RE: 6/2020/1181/COND – Northaw House, Coopers Lane, Northaw, Potters Bar, EN6 4NG

Thank you for consulting us on the above application for the submission of details pursuant to condition 1 (surface water drainage scheme) on planning permission 6/2019/0217/MAJ at Northaw House, Coopers Lane, Northaw, Potters Bar, EN6 4NG.

We have reviewed the covering note and appendices prepared by Civilistix reference DRM/CIV/1-046 dated May 2020 submitted in support of this application.

DRAWING TITLE: **PROPOSED POND SECTIONS**

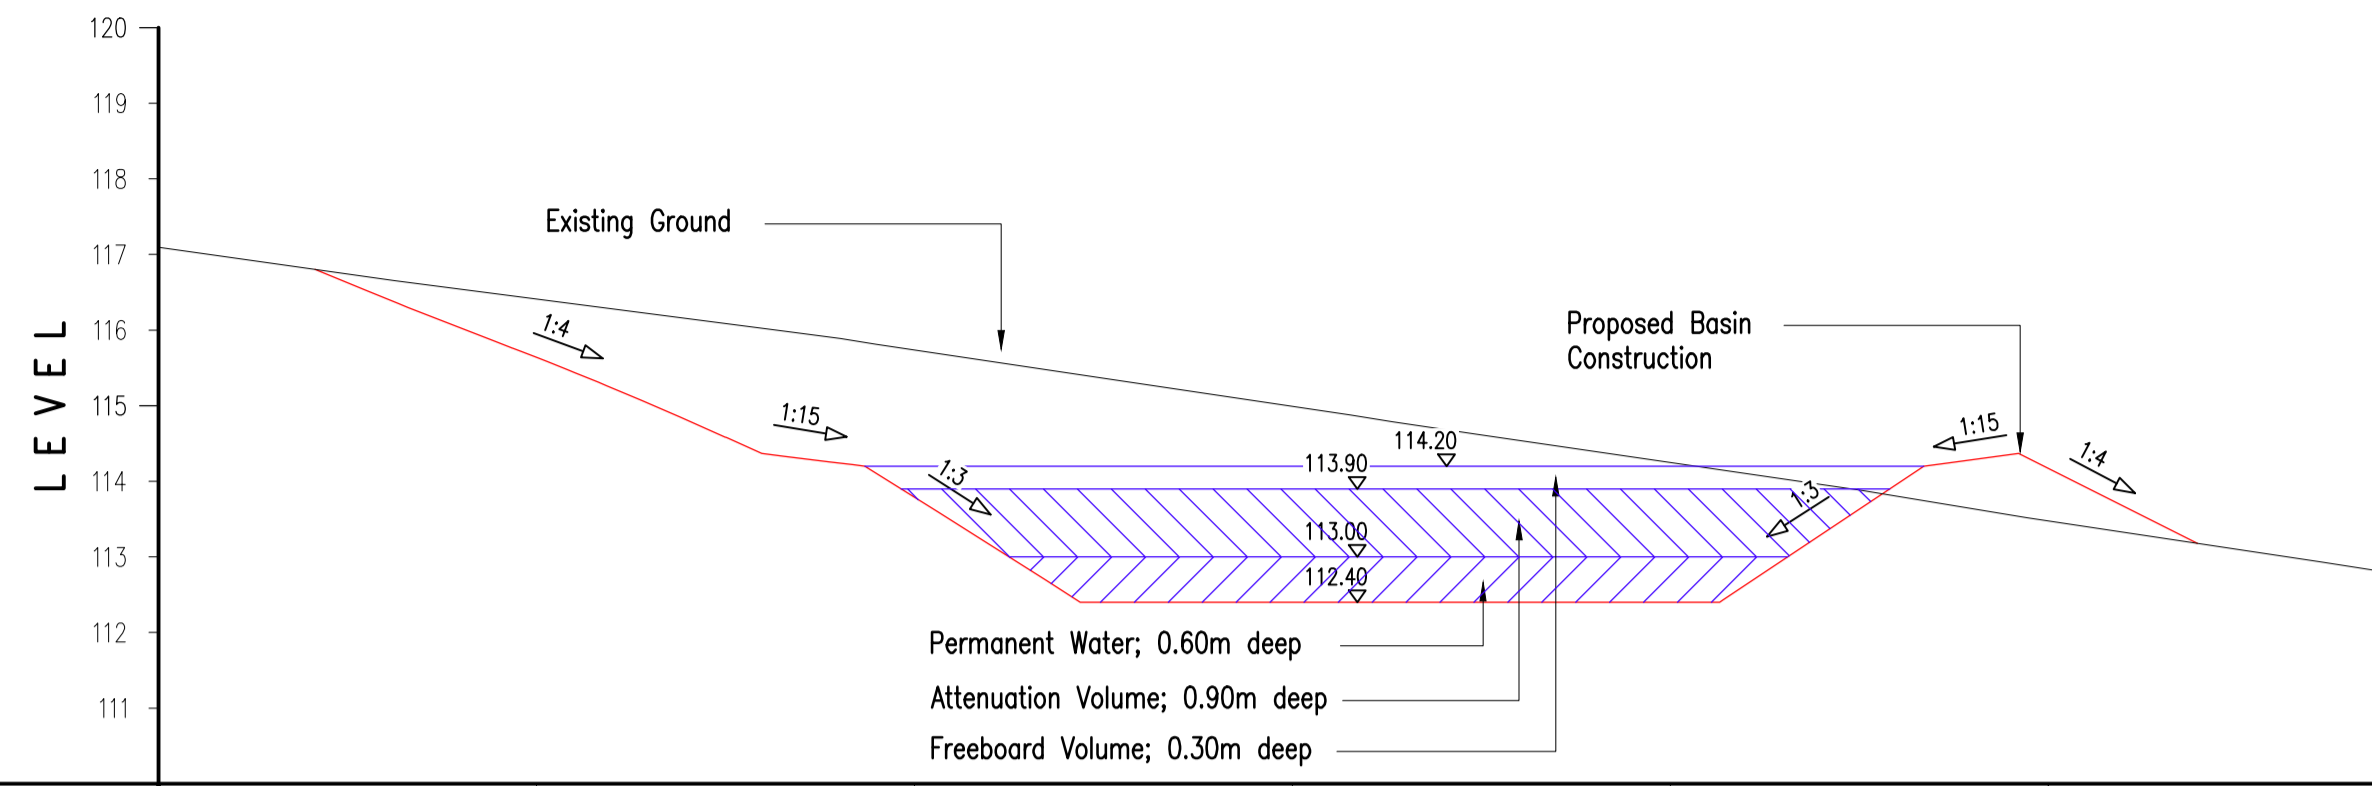
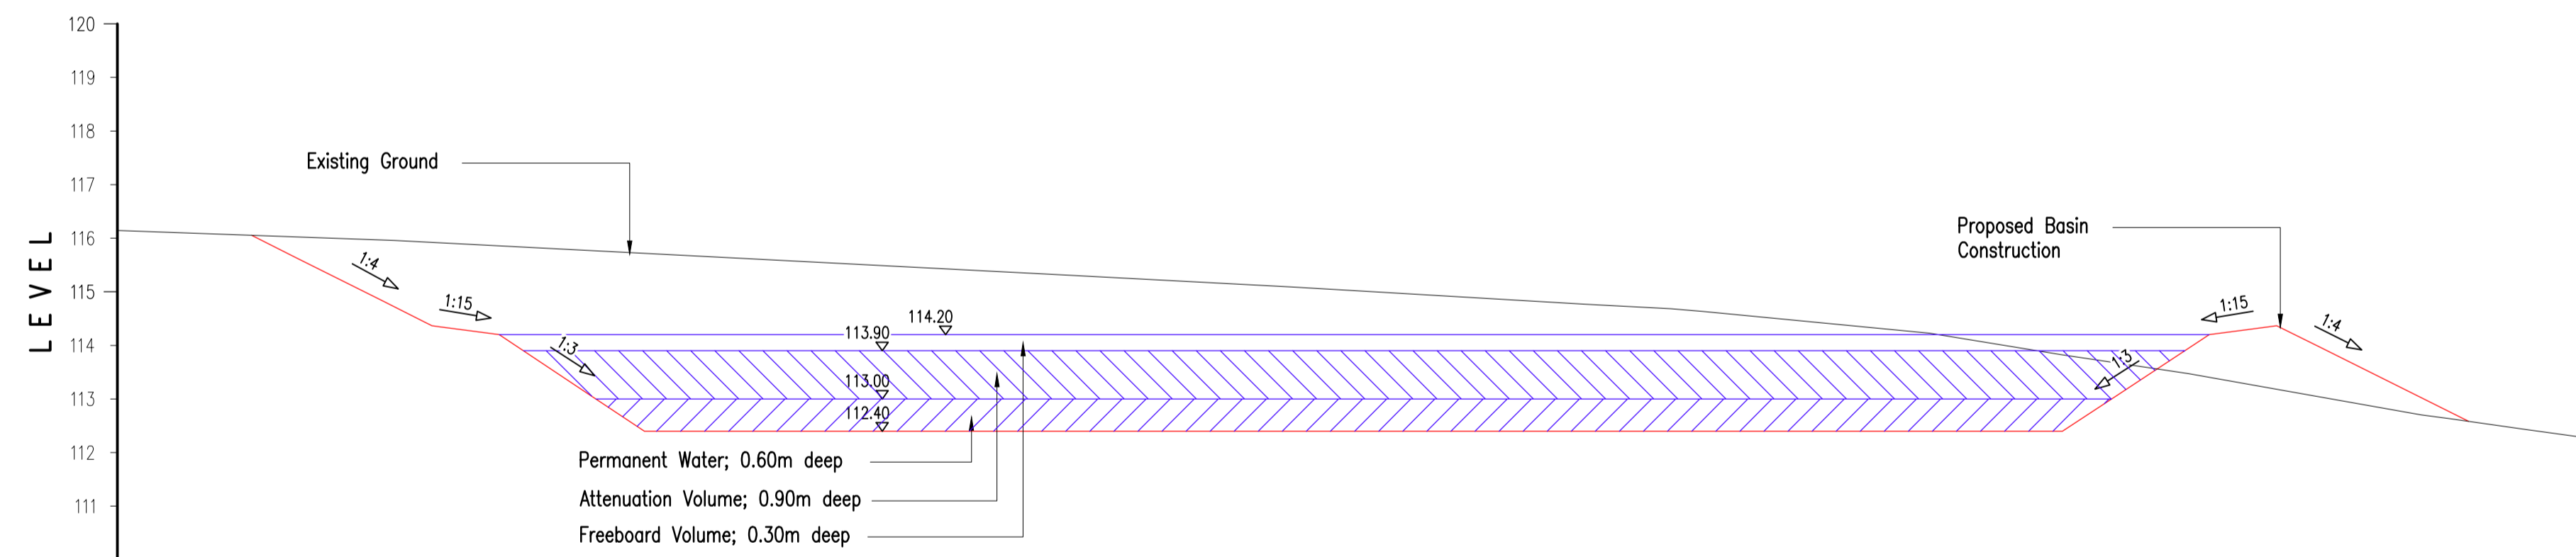
The applicant has provided calculations for the 1 in 100 year + 40% climate change event and confirms that the basin size has been increased to provide a total volume of 1480 m³, which will provide attenuation for the 1 in 100 year + 40% climate change storm followed by a 1 in 30 year storm.
